Planning & Infrastructure

Our ref.: MP11_0009

Subject: Exhibition of Miranda Dental Hospital – 84-86 Kiora Road, Miranda Sutherland Shire Council (MP11_0009)

SCHEDULE 1 – KEY ISSUES

basement floor plan
scale: 1:100

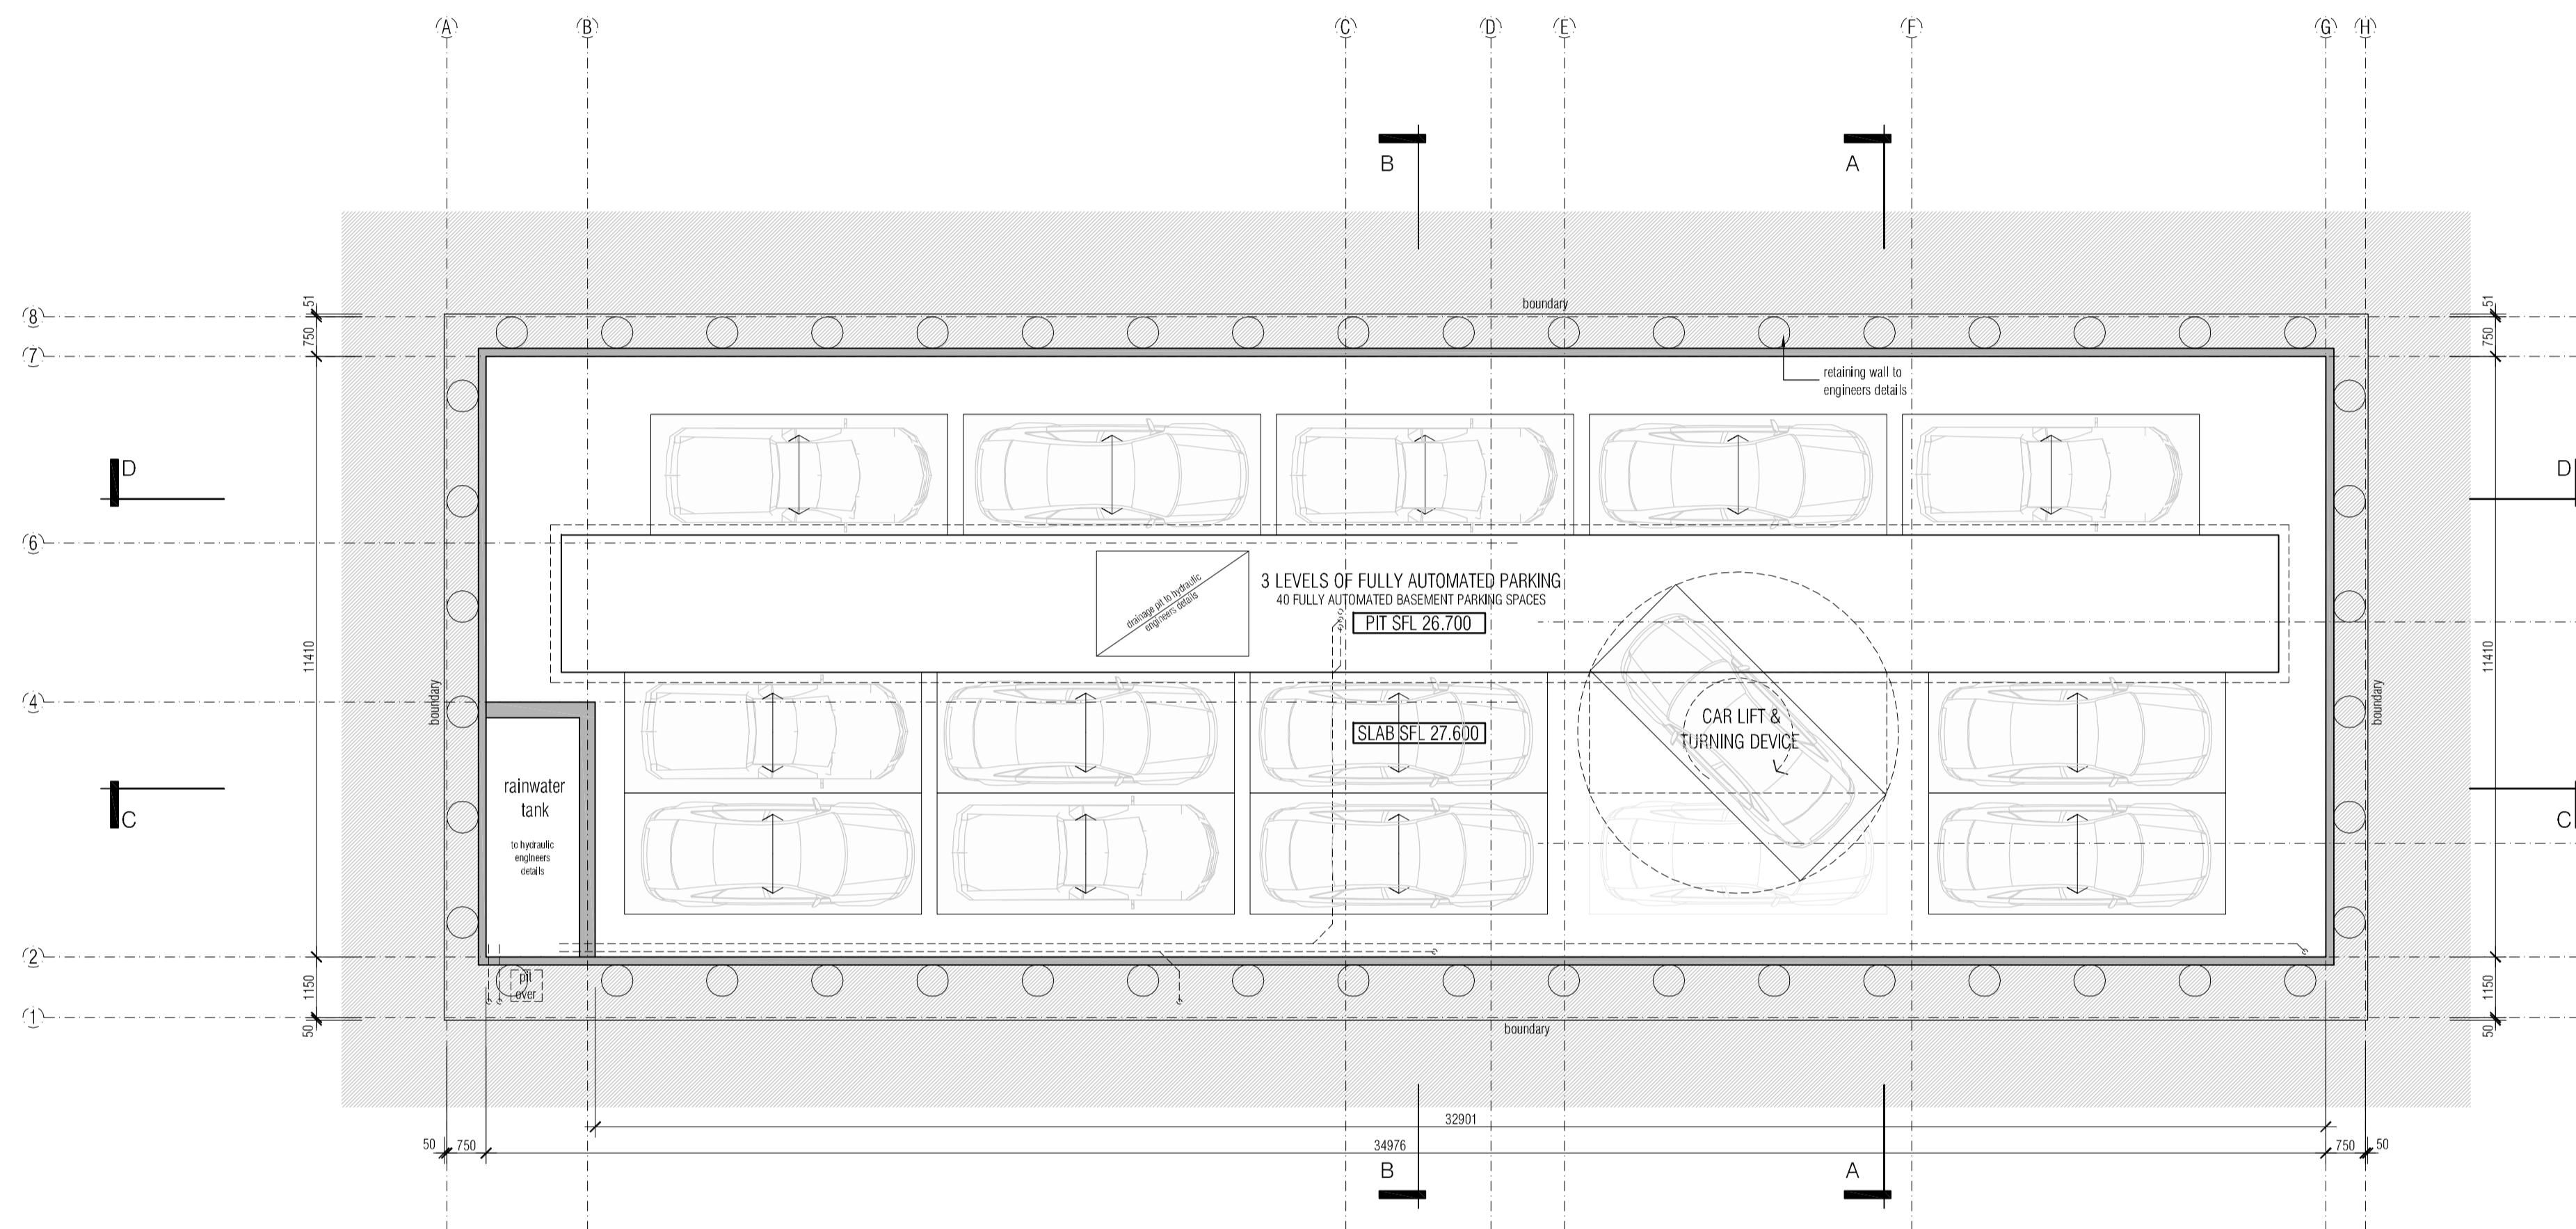
- The department raises the following concerns in relation to the proposed car parking and vehicular access arrangements:
 - no on-site patient car parking or pick-up/ drop-off area;

- reliance on a car-stacker for 43 staff spaces and the likely on street traffic queuing impact is not acceptable; and
 - accessible parking and loading spaces are inadequate.A revised design addressing the above should be considered. The Department strongly encourages a reduction in the number of staff car parking spaces noting the site's proximity to public transport.

LOWER & UPPER GROUND FLOOR PLANS

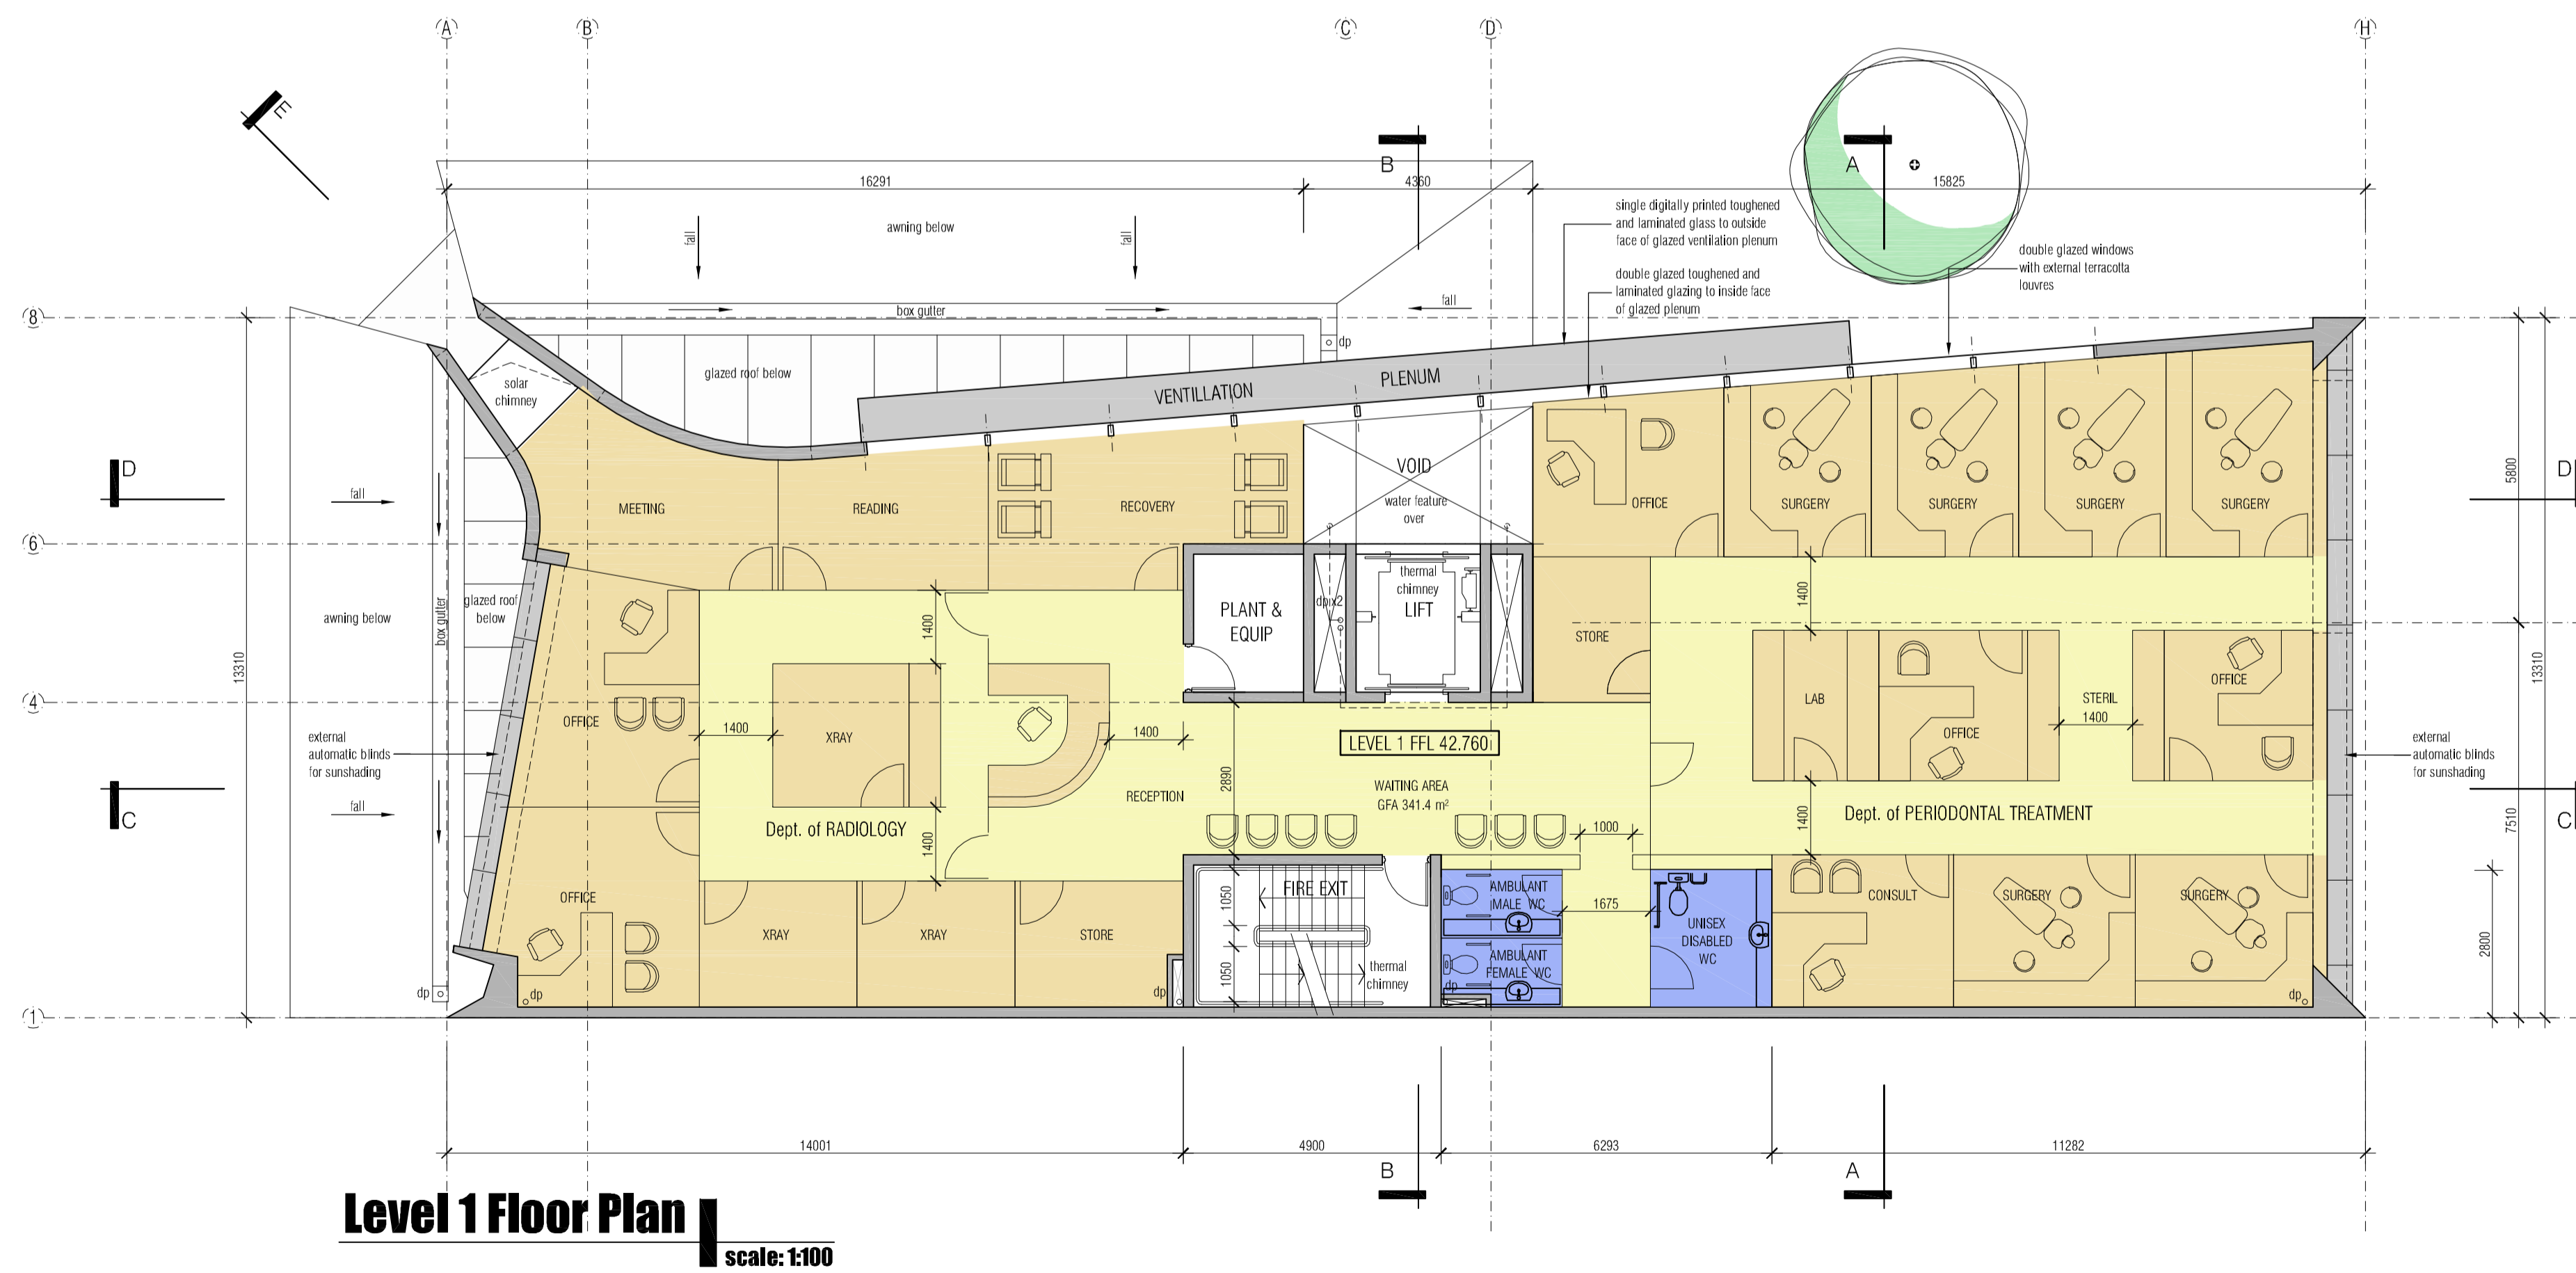
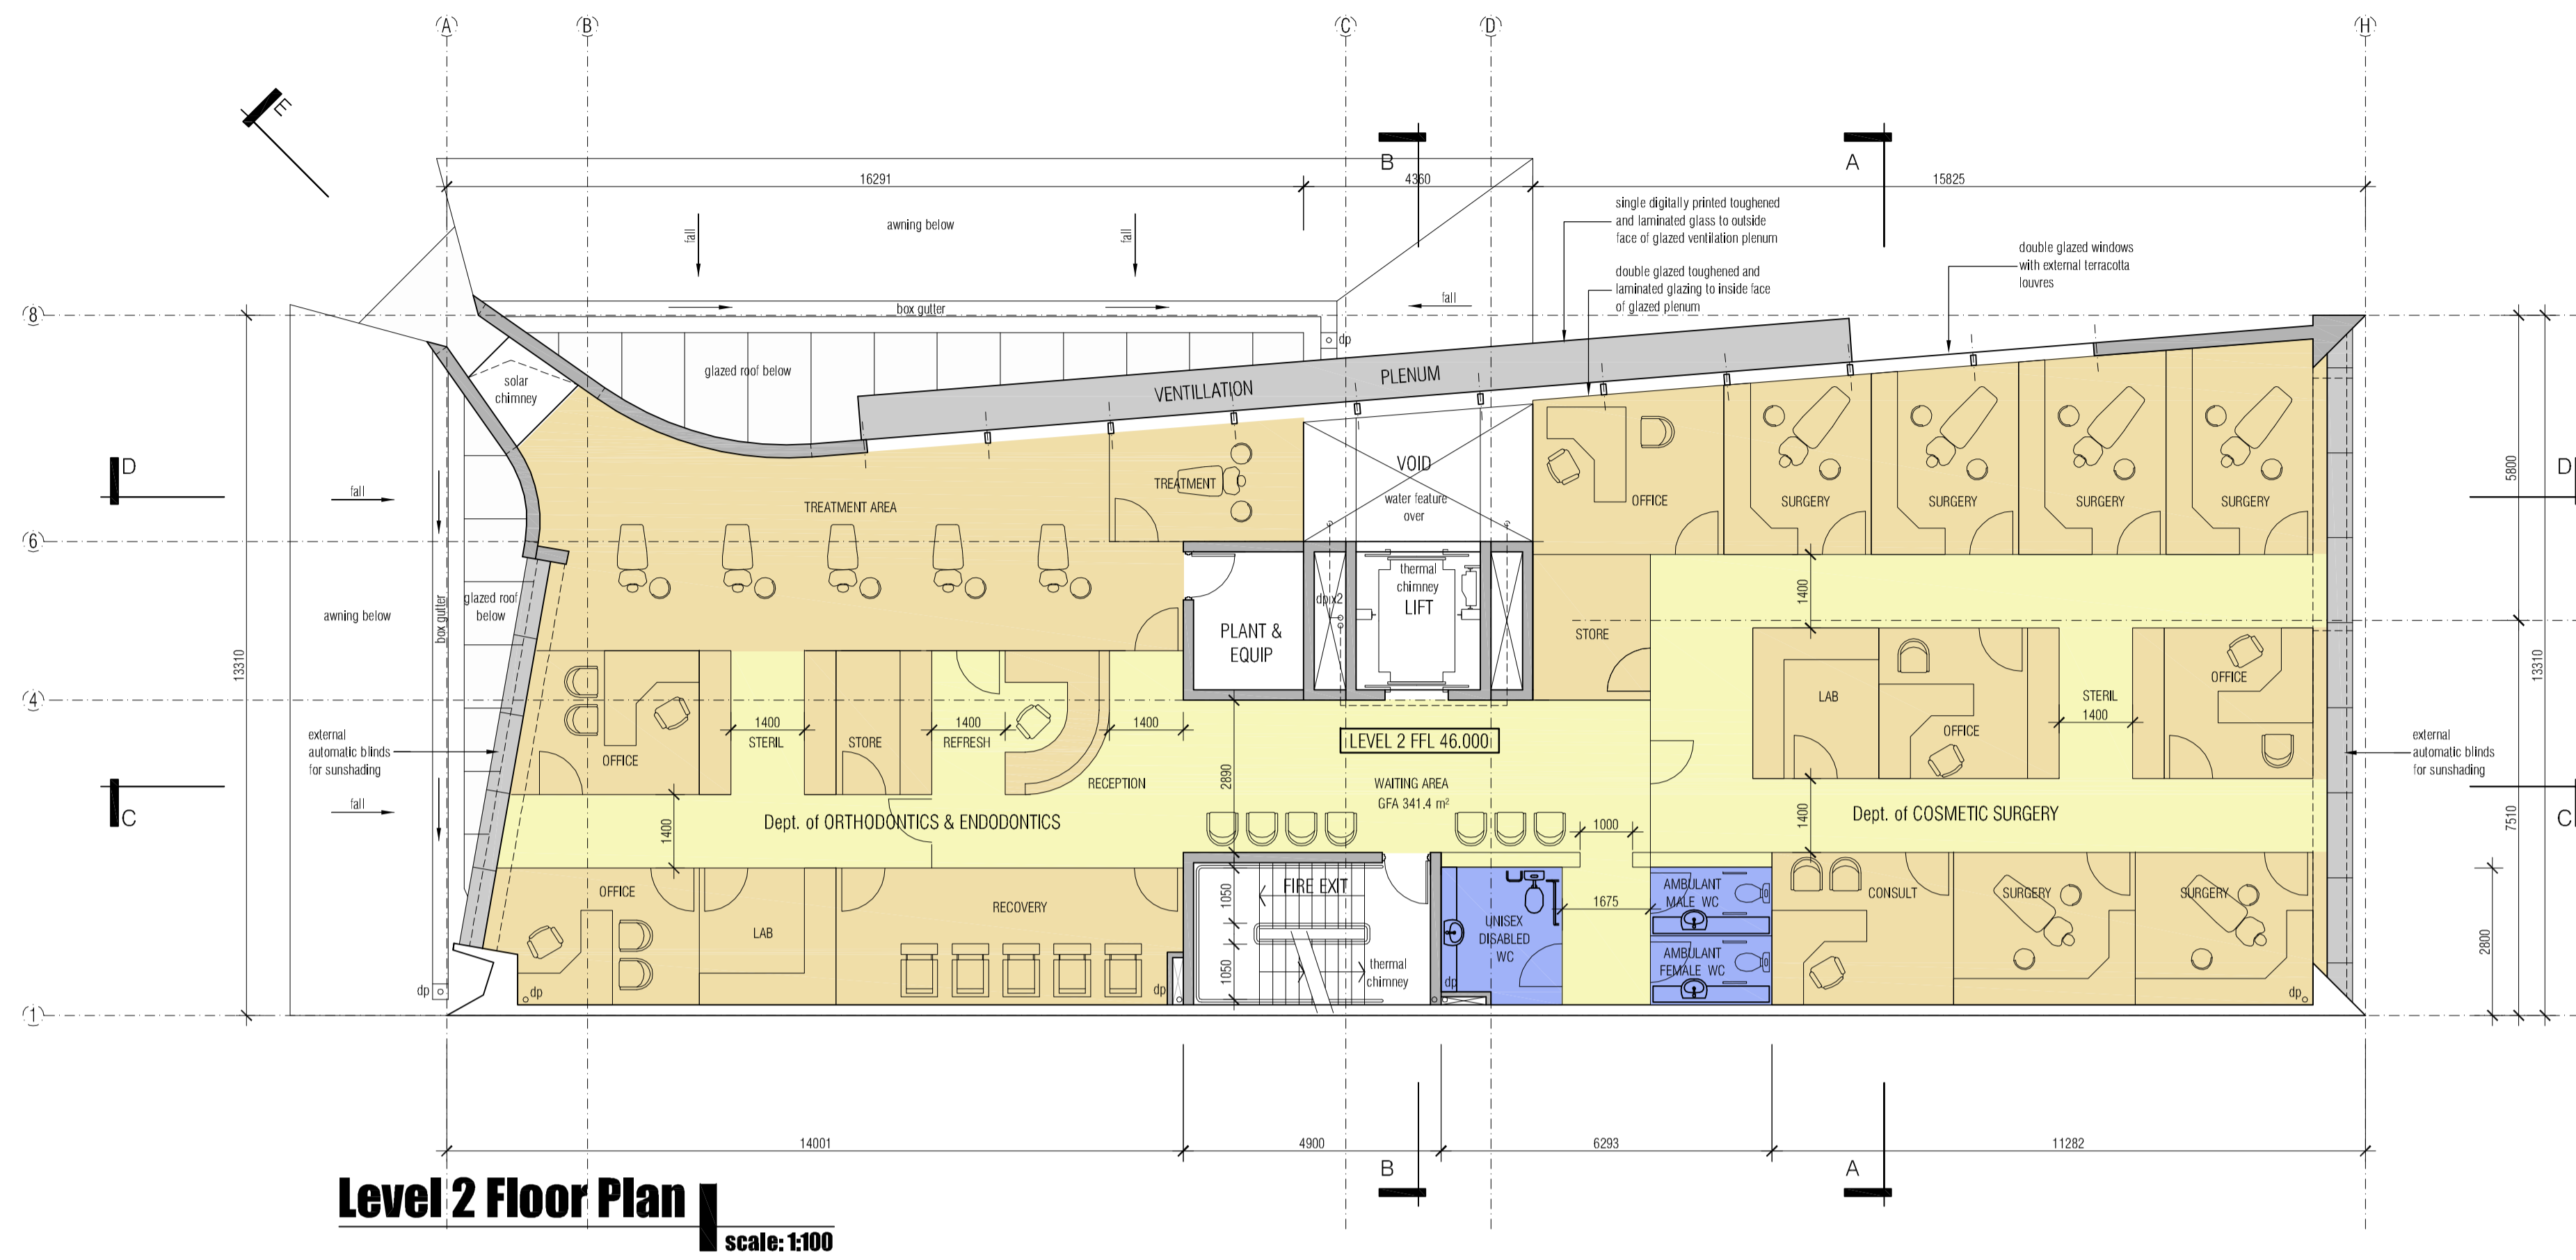
- Consideration of a setback at the ground floor to accommodate the provision of a pedestrian colonnade at Kiora Road, to provide an appropriate pedestrian linkage between the railway station and Westfields Shopping Centre.
- Further consideration of the upper level treatment of the southern elevation to limit the future impact of any redevelopment of adjoining sites to the south, to the development.
- Consideration of greater articulation to the southern elevation to prevent a sheer street wall at the lower levels prior to any redevelopment of adjoining sites to the south.
